RE: Nowak Short Plat SP-10-00009

Thank you for the opportunity to comment on the Nowak Short Plat, SP-10-00009.

*NOWAK*  
**ALEXANDER SHORT PLAT**  
WITHIN THE SW 1/4 SECTION 3 T18N R18EW  
KITITAS COUNTY WA.

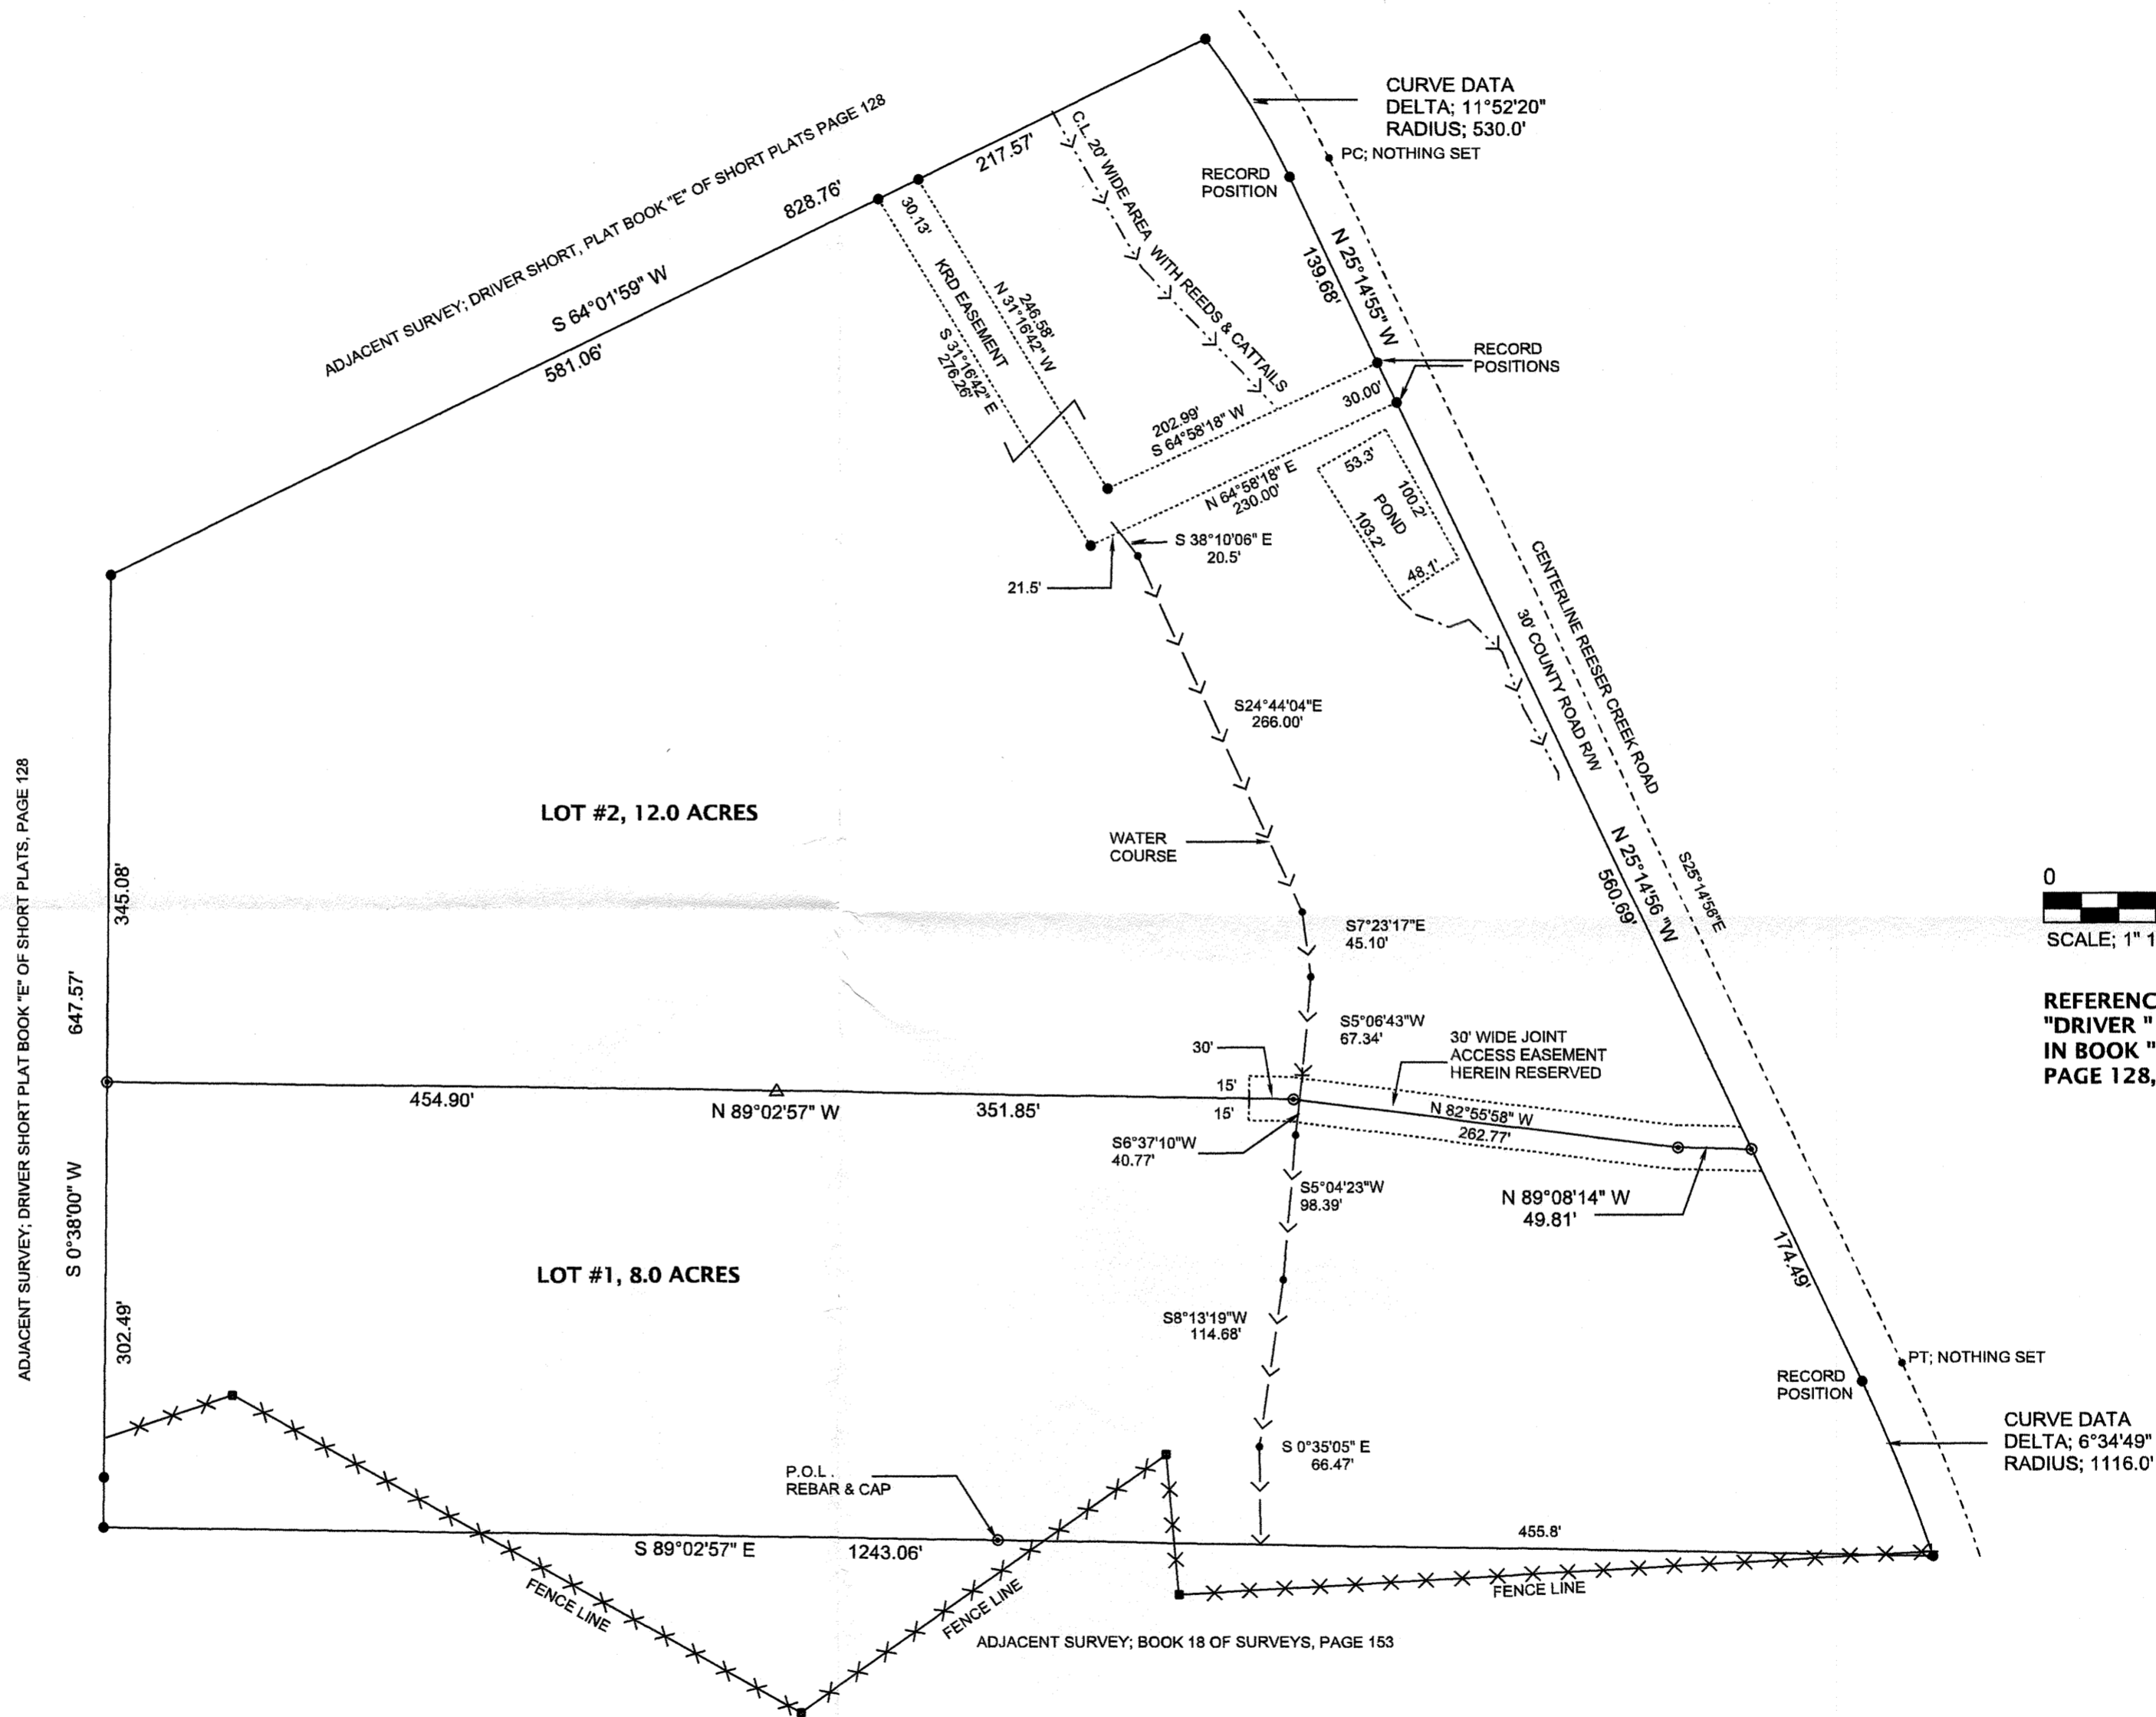
Plat Note Statement:

The final plat notes shall include the following two statements:

"The approval of this division of land includes no guarantee that there is a legal right to withdraw groundwater within the land division. The approval of this division of land provides no guarantee that use of water under the ground water exemption (RCW 90.44.050) for this plat or any portion thereof will not be subject to curtailment by the Department of Ecology or a court of law. "

At this point in time this application does not contain sufficient information to make a determination that: 1) there is an adequate potable water supply available and 2) that the land area is suitable for onsite sewage systems. The above mentioned requirements need to be satisfied and the appropriate documentation needs to be submitted to the Public Health Department for review and approval in order for the plat application to be recommended for approval.
